**Attention: Director, Infrastructure Projects - North West Rail Line - EIS 2 (SSI-5414)**

I write with reference to the opportunity to provide comment on the second Environmental Impact Statement relating to the construction of the North West Rail line – application no. SSI-5414.

Figure 6.40 Cudgegong Road Station - Indicative vehicle and pedestrian movements

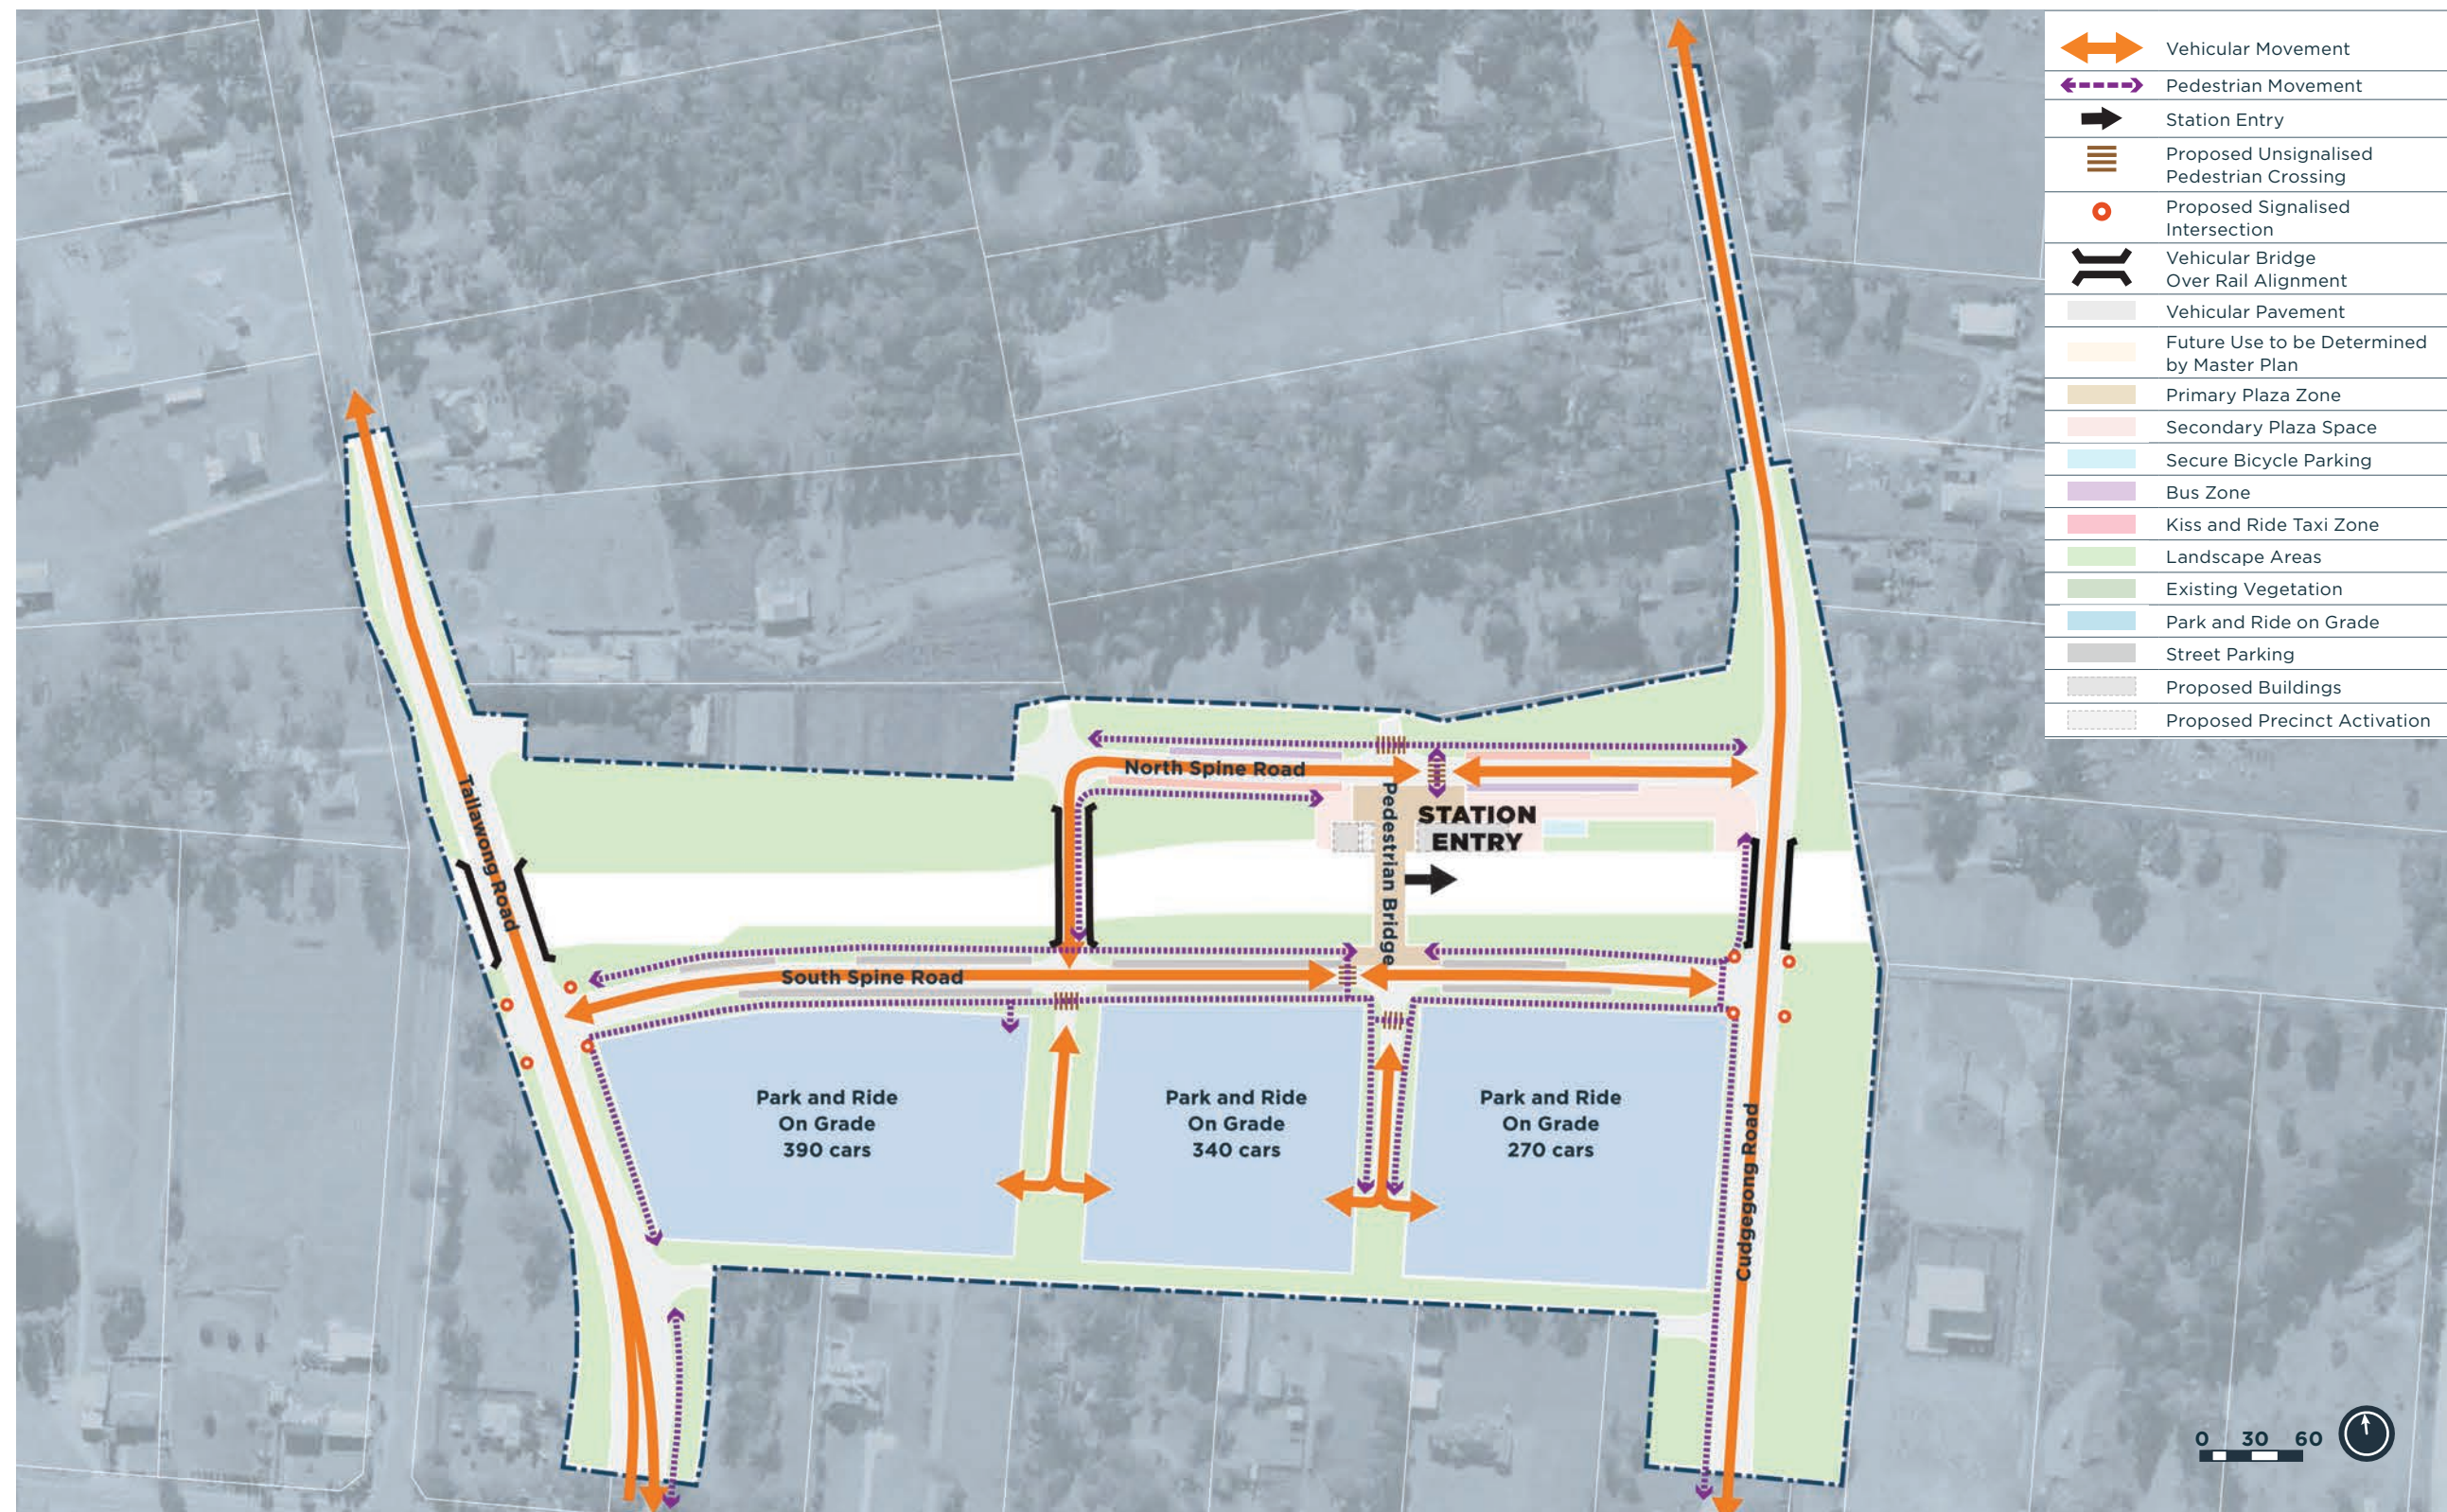
It is noted that the design for this interchange sees buses allocated rank space on both sides of the ***northern*** spine road. (EIS 2 - Operation Traffic and Transport Management Plan pg. 149).

The utilisation of the northern spine road introduces inefficiency into bus operations in this precinct. This is owing to the fact that this road does not connect full-length between Cudgegong Rd and Tallawong Rd. Rather, two additional turning movements are required to complete this leg of the bus route servicing this station.

Therefore, given that the station has direct pedestrian access to both the northern *and* southern spine roads, consideration should be given to providing bus ranks on both sides of the ***southern*** spine road in the vicinity of the station access point.

Since the southern spine road is planned to directly connect Cudgegong Rd and Tallawong Rd, it would be odd to ignore it as the logical choice for bus routes through the station precinct, which could then operate in a simplified and hence more efficient manner.
